Recommendation Report for Planning Permission for Works or Extension to a Dwelling

REF NO: R/77/22/HH

LOCATION: 19 Sea Avenue
Rustington
BN16 2DQ

PROPOSAL: Two storey side extension.

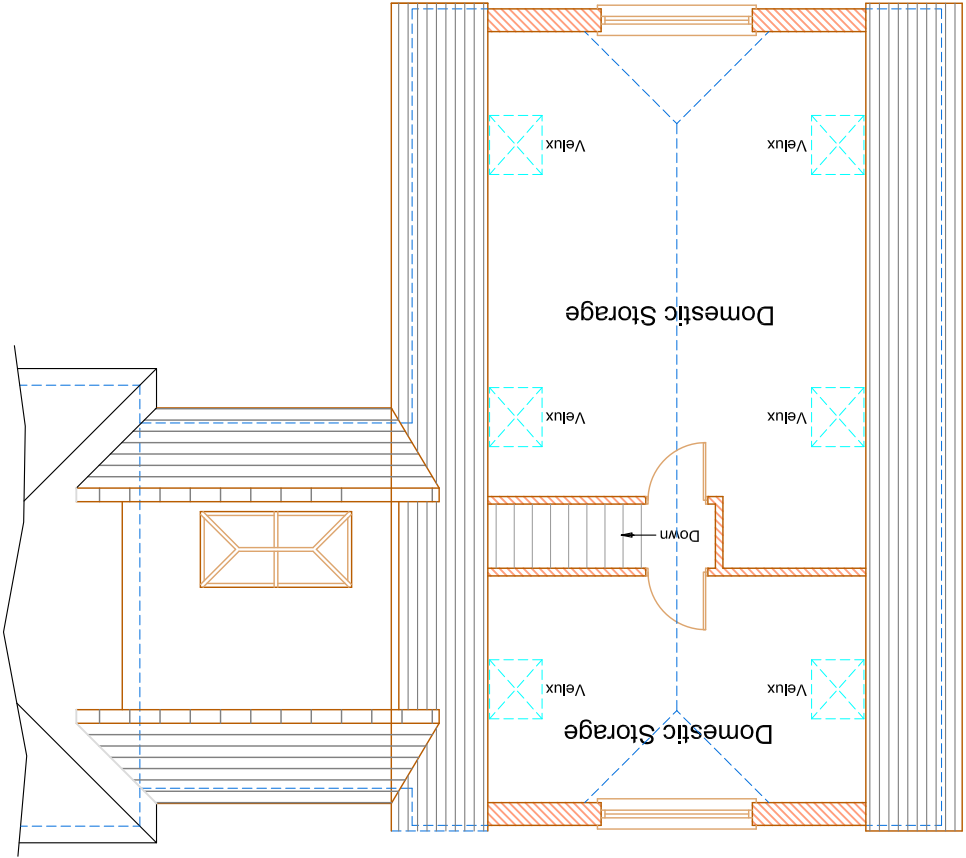
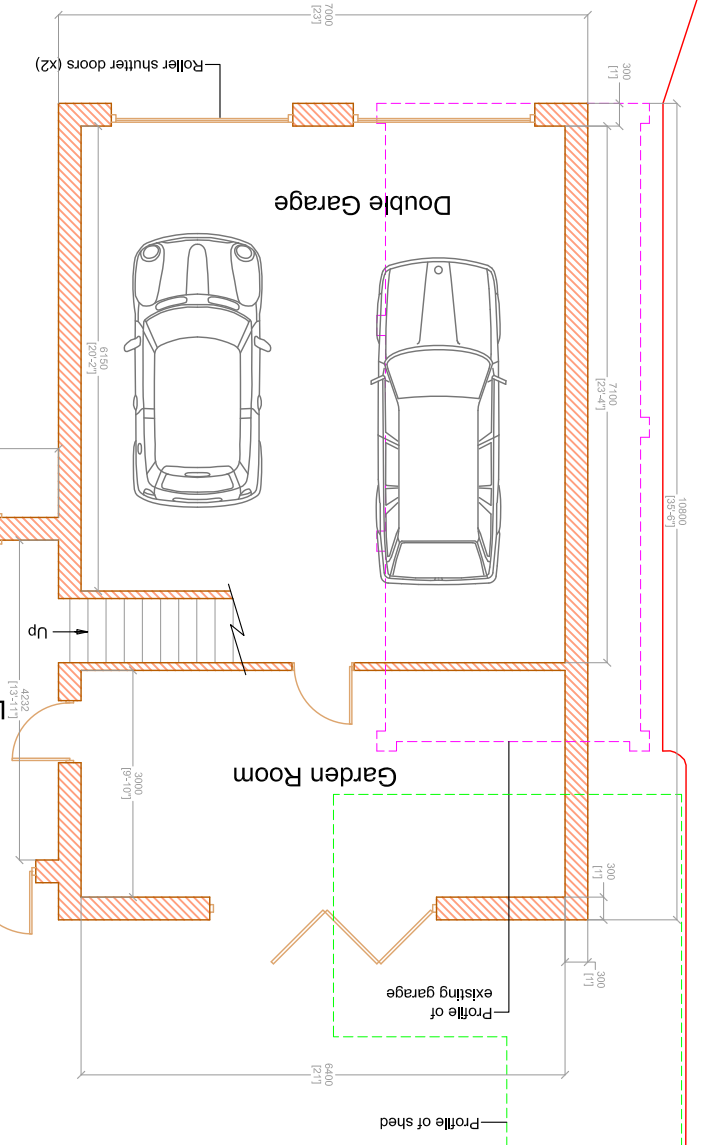
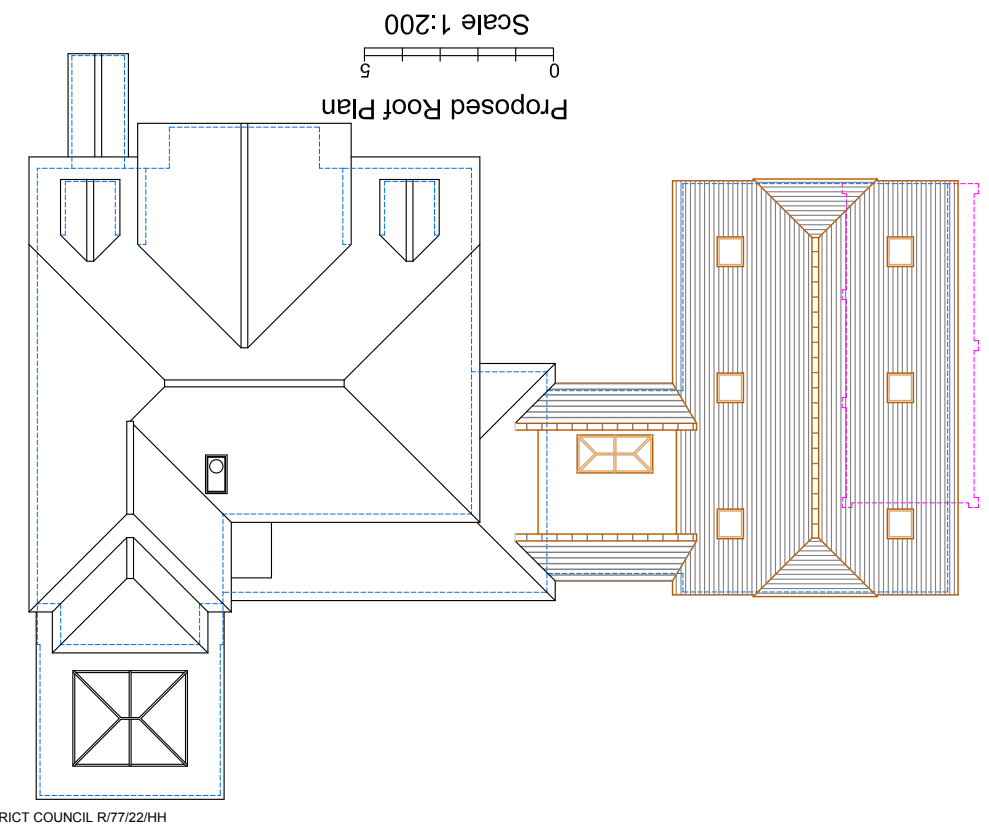
In terms of overlooking, new fenestration will be introduced at first floor level to the western, northern and

eastern elevations. The 3 rooflights to the northern elevation are of most concern. It is noted that these windows face towards a habitable first floor window to the southern elevation of No. 17 Sea Avenue. To introduce windows without restriction to the first-floor northern elevation of 19 Sea Avenue would have an unacceptable adverse effect to the adjoining occupiers in terms of a negative impact to privacy levels. To address this they will be conditioned to be obscured glazed and non-opening.

- Proposed Elevations 21/4865/5 (except of the 3 rooflights shown to the Northern Elevation)
- Proposed Floor Plans 21/4865/4 (except of the 3 rooflights shown to the Northern Elevation)
- Location and Block Plan 21/4865/1

- 3 The 3 rooflights hereby approved to the northern elevation shall be non-opening and have fully obscured glazing prior to the first use of the rooms. The windows shall be retained as obscure glazed/non-openable in perpetuity.
